Re: Response to PCD Engineering Review
Soil, Geology, & Geologic Hazard Study
Retreat at TimberRidge Filing No. 3
El Paso County, Colorado
Entech Job No. 221106

Ref: Entech Engineering, Inc., dated June 10, 2022, Soil, Geology, & Geologic Hazard Study, Retreat at TimberRidge, Filing No. 3, El Paso County, Colorado. Entech Job No. 221106

Colorado Geological Survey, February 2, 2023. Retreat at TimberRidge, Filing No. 3. *El Paso County, Colorado*; EPC File No. SF2241.

GEOLOGY MAP/ENGINEERING GEOLOGY
 RETREAT AT TIMBRIDGE, FILING 3
 VOLLMER ROAD AND ARROYA LANE
 EL PASO COUNTY, CO.
 FOR: TIMBRIDGE DEVELOPMENT GROUP, LLC

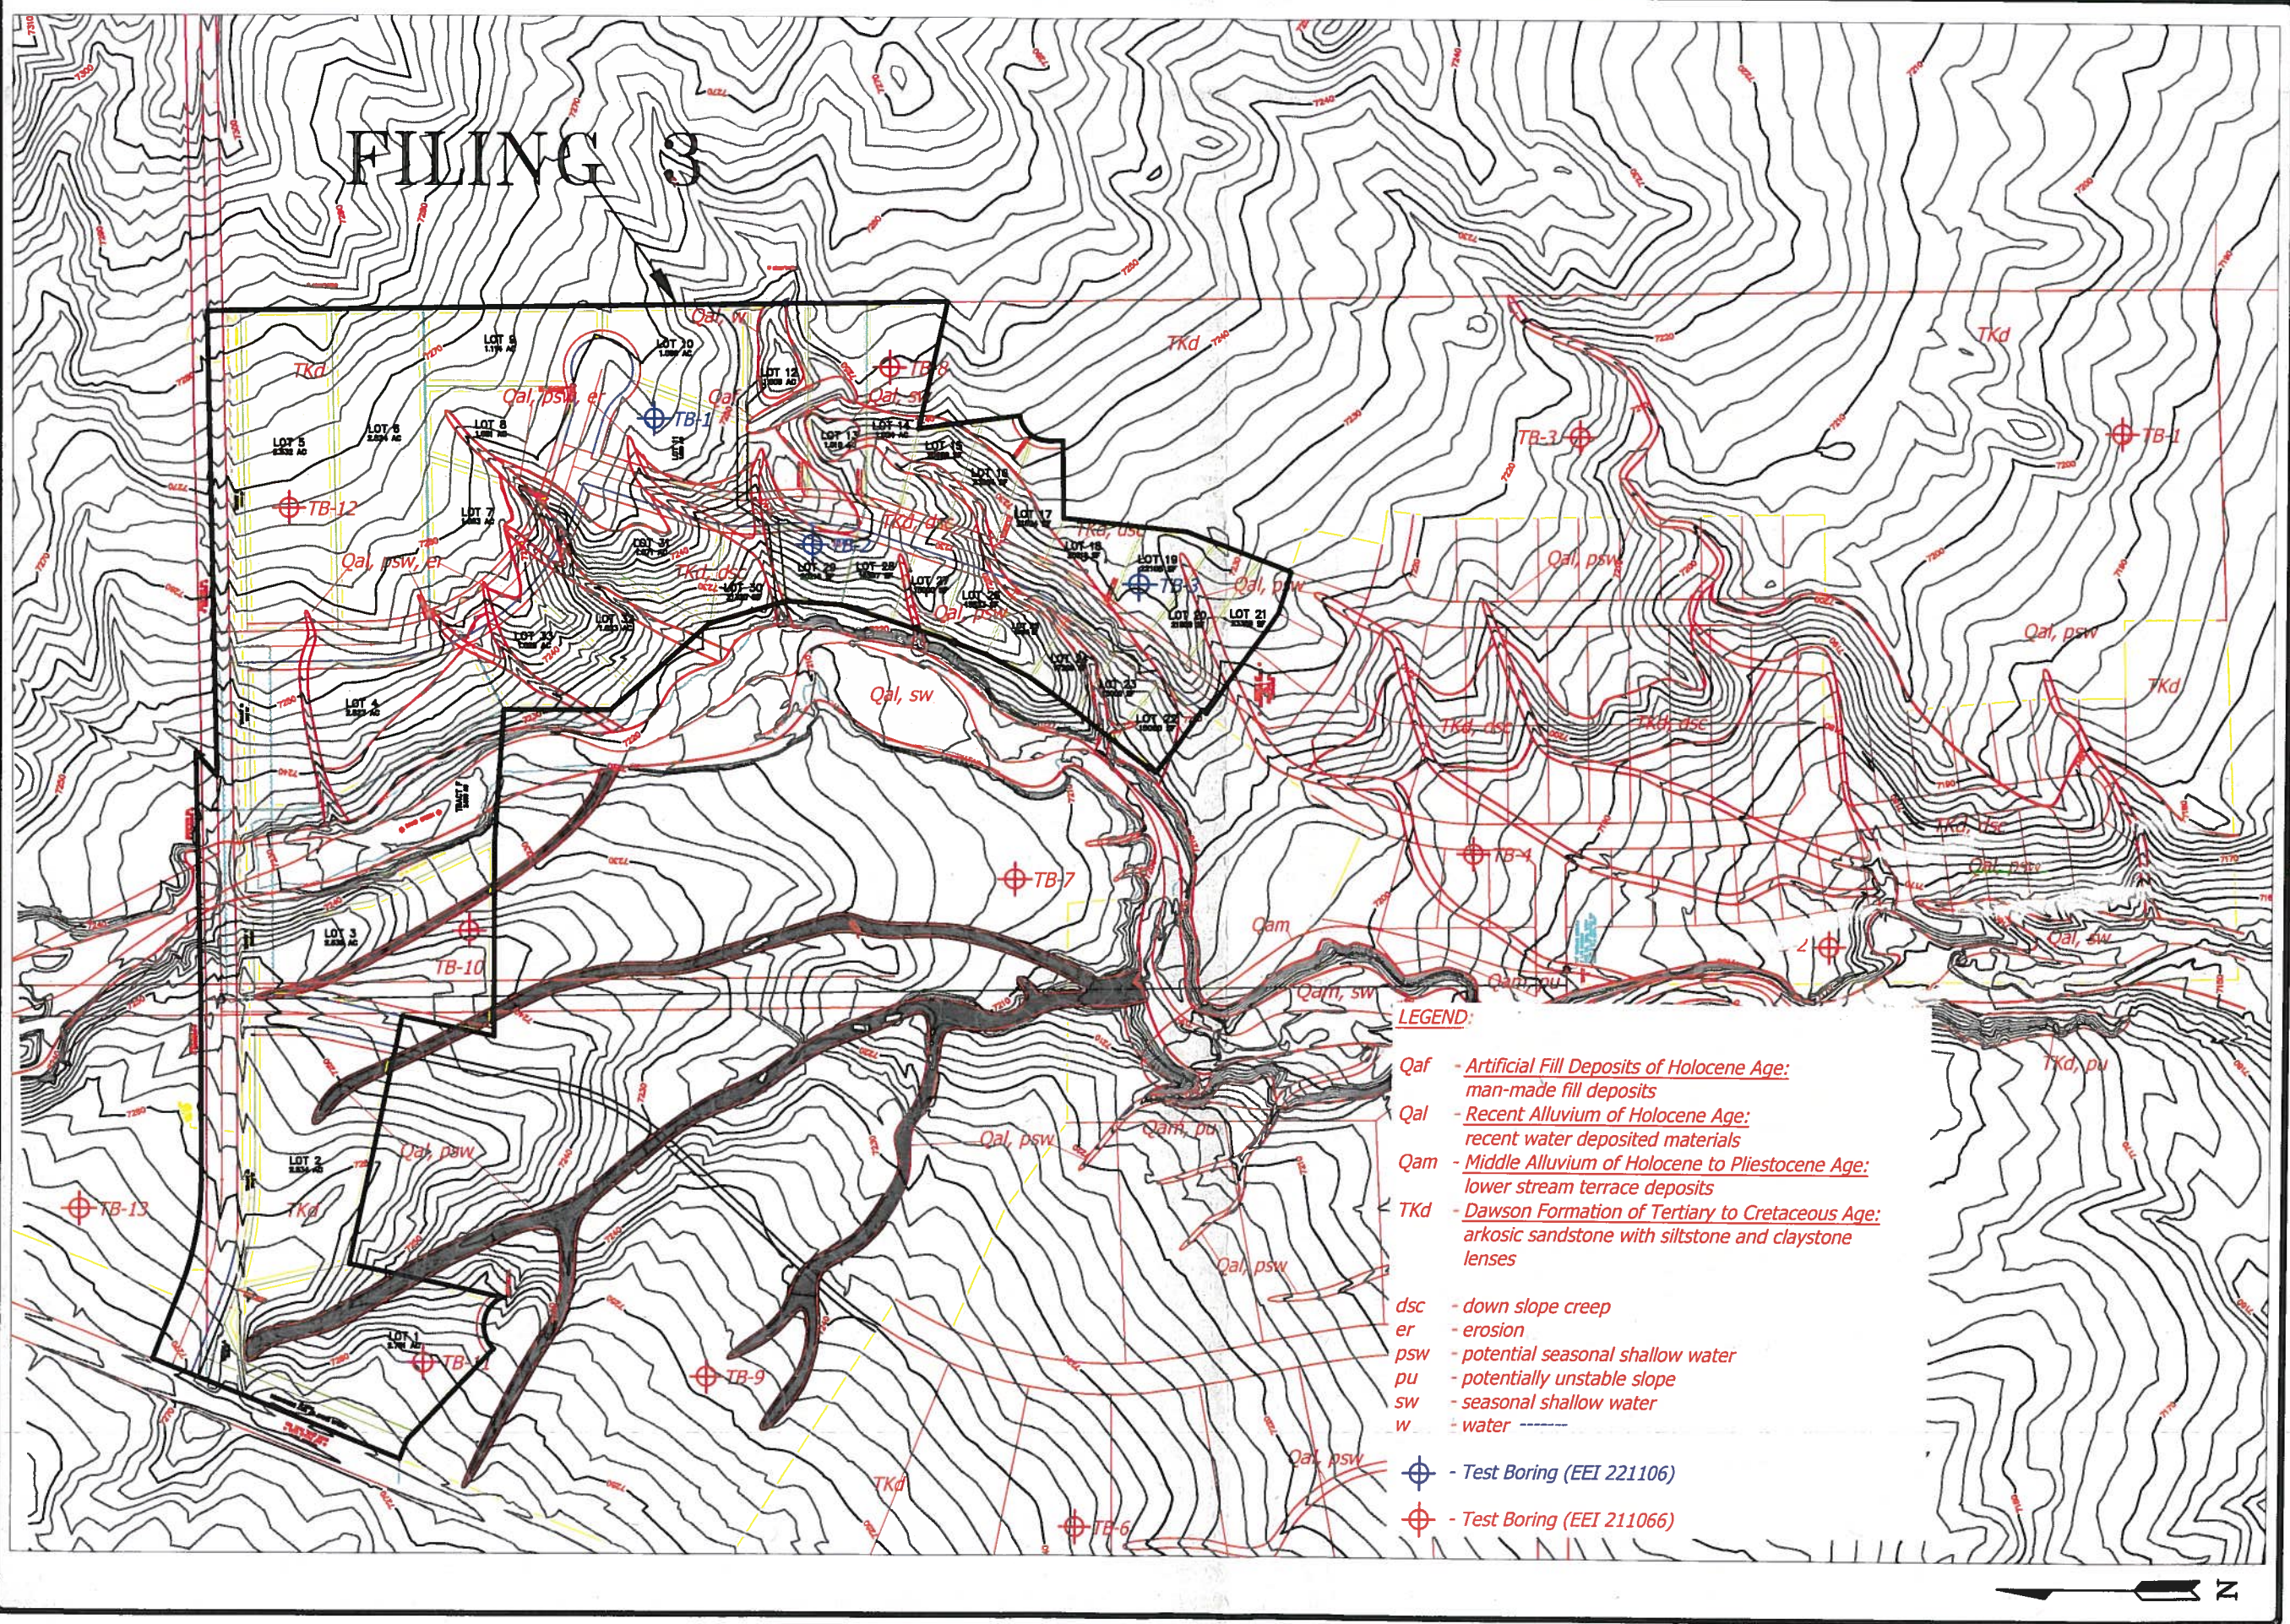
CGS Comment: *“Entech identified areas of downslope creep but states on page 12, “It is anticipated that many of these areas will be mitigated by overlot grading.” Once final grading is completed, Entech Should review the grades to verify these areas will be mitigated. Entech’s recommendation should be incorporated into the design of foundations.*

Entech Response: Entech agrees with the CGS comment and will review grades once grading is completed. Reviewing the available grading plan revised date September 21, 2023, Lots 4, and 31 – 33 that have been mapped with the potential for downslope creep will have minimal grading along the roadways. These lots will need to account for the higher lateral pressures from the downslope creep in the foundation designs. Mitigation for downslope creep will be determined for each lot as construction is performed. Lots 23 – 30 will be regraded with walkout slopes proposed.
